CITY OF ALBUQUERQUE

October 15, 2018

Re: Townhouse for Ahmet Tiriyaki
910 Chelwood Blvd. N.E., Lot 1A, Block 11, Albuquerque, NM 87112
Traffic Circulation Layout
Engineer's/Architect's Stamp 10-11-18 (J22D070)

DRAWING TITLE: TRAFFIC CONTROL LAYOUT

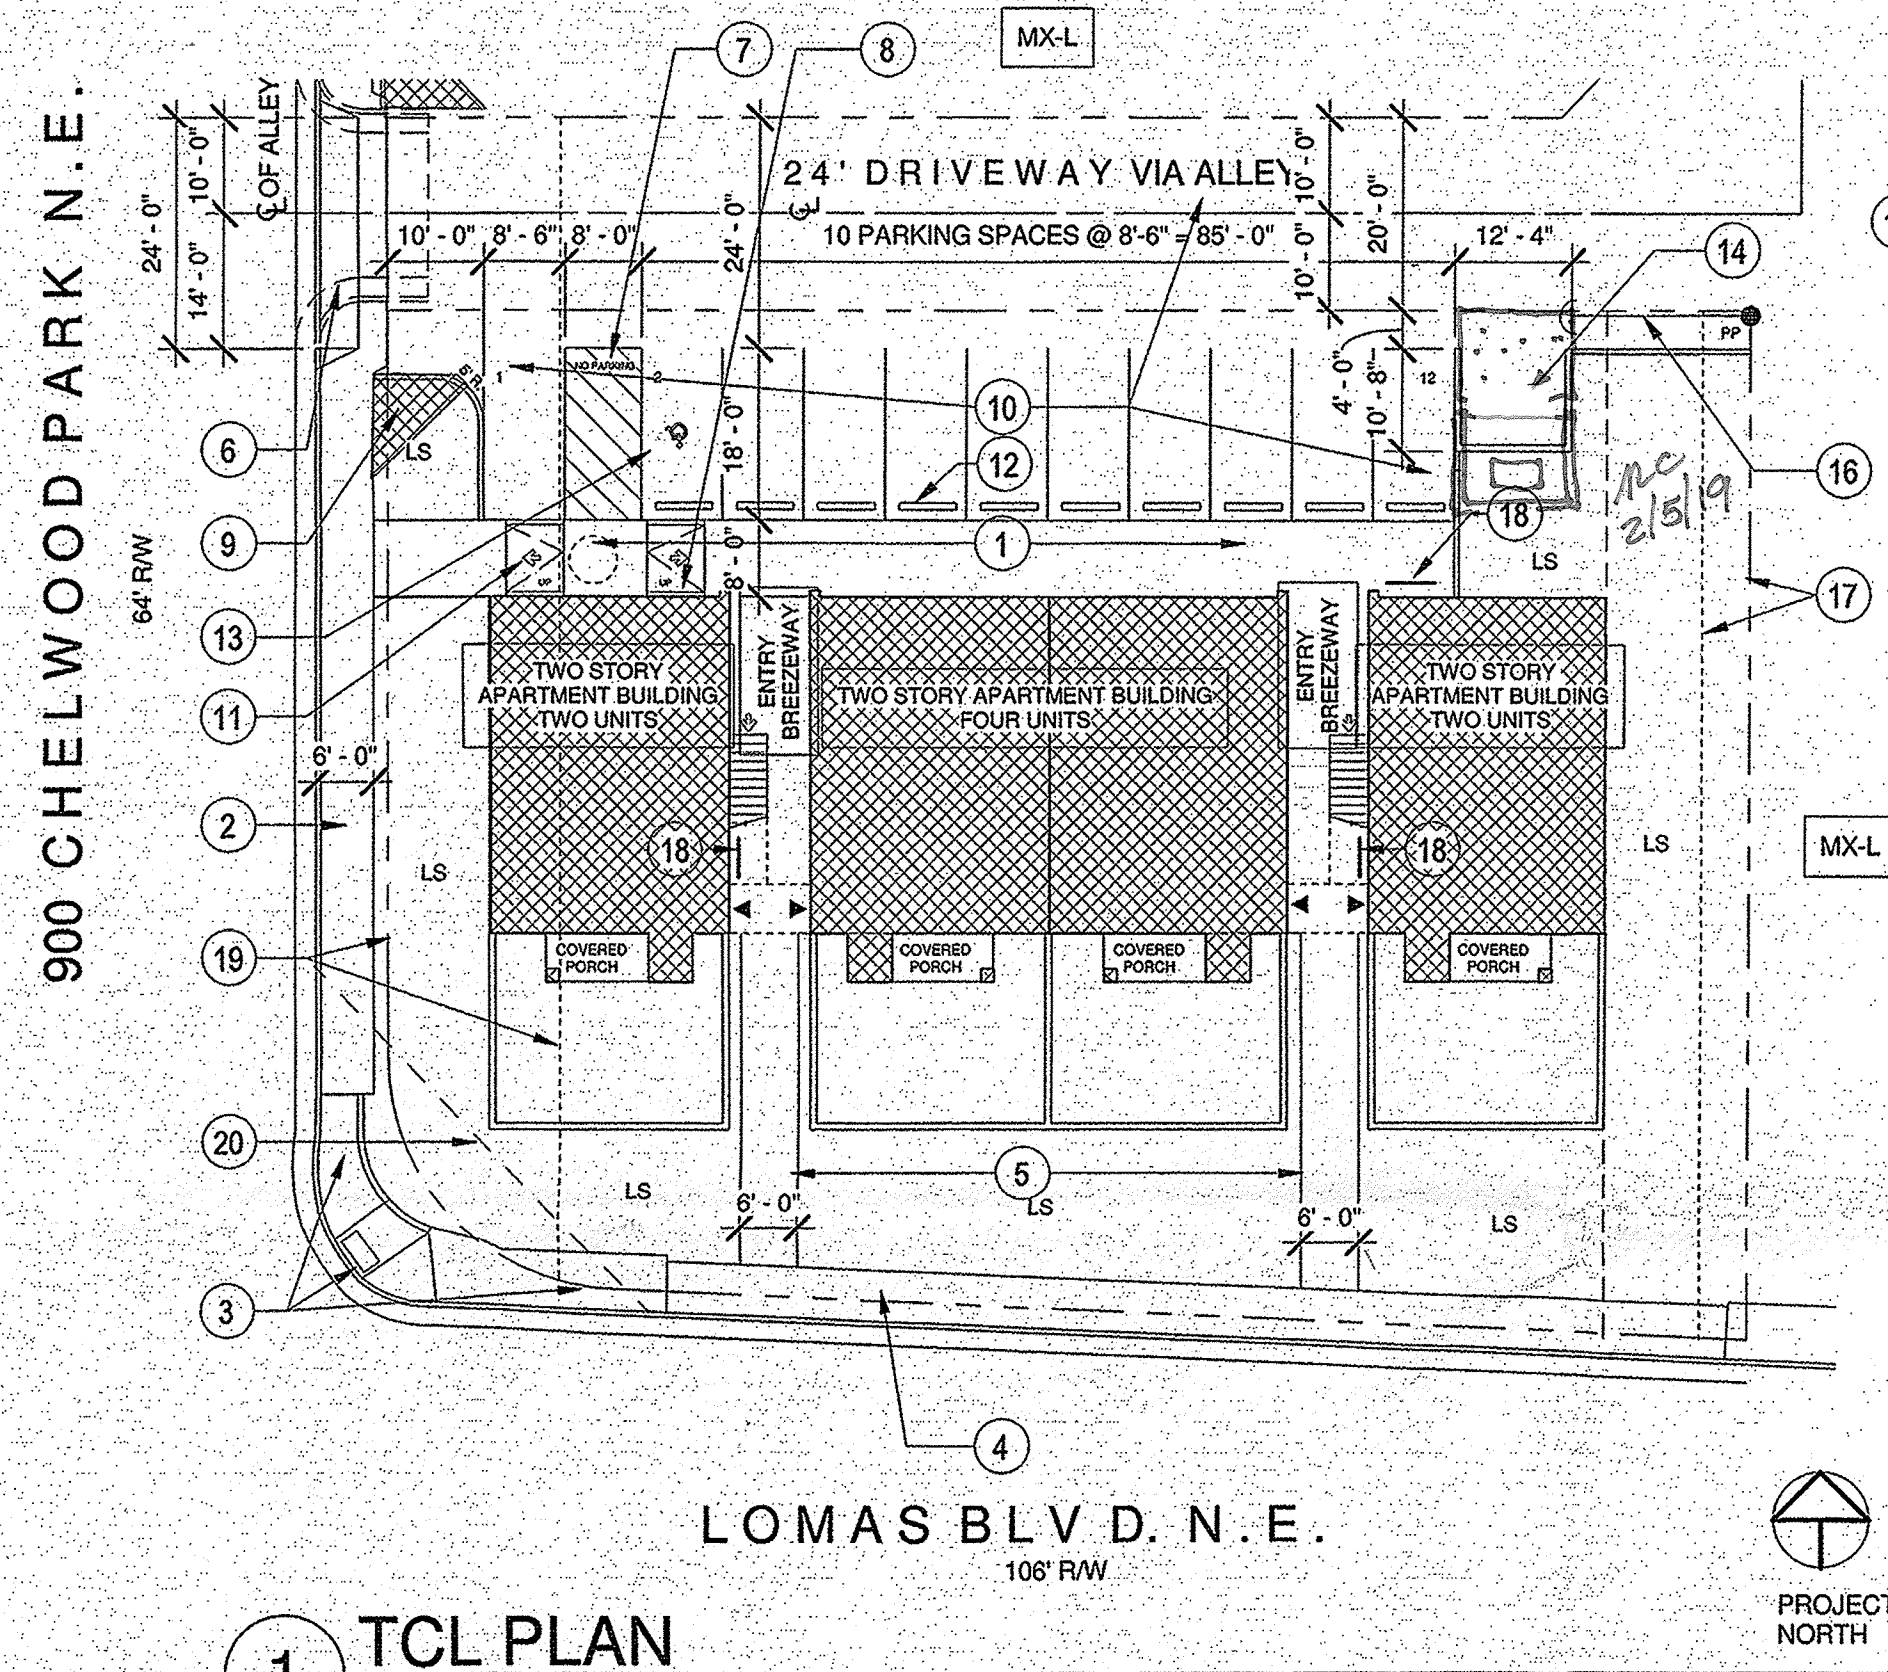
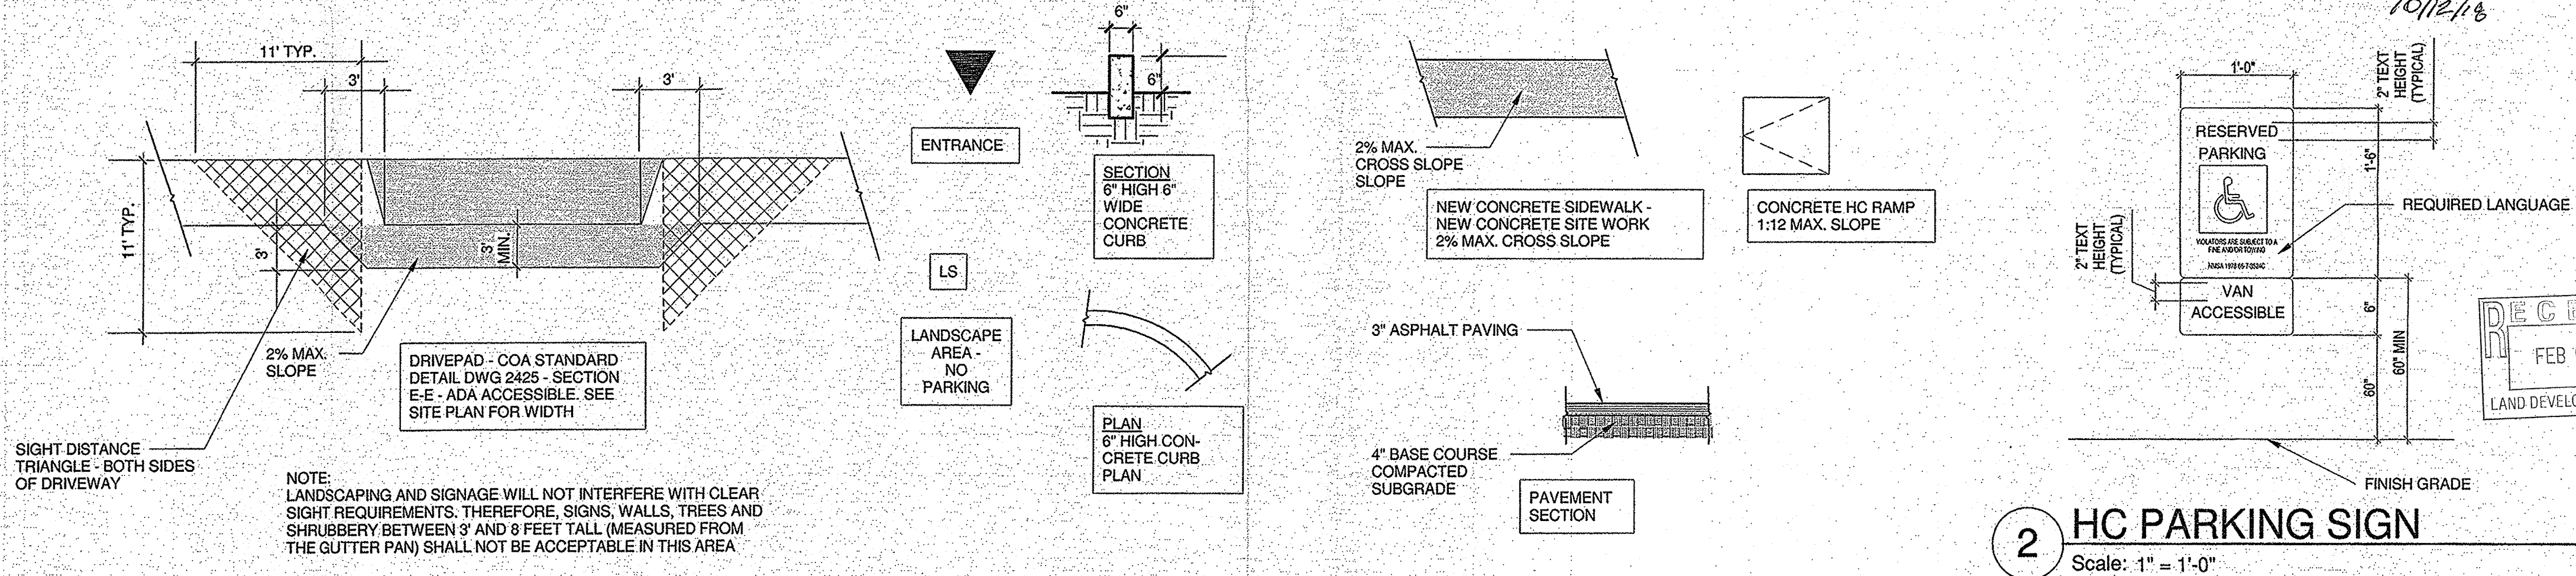
1. Move the refuse container further to the south and provide a concrete surface in front of the refuse tank.
2. A work order for the sidewalk on all public properties should be submitted before TCL approval.(Chelwood park and Alice Ave and Alley pavement)
3. Please add a note on the plan stating "All improvements located in the Right of Way must be included on the work order."
4. The certificate of Occupancy will be held for work order close out.
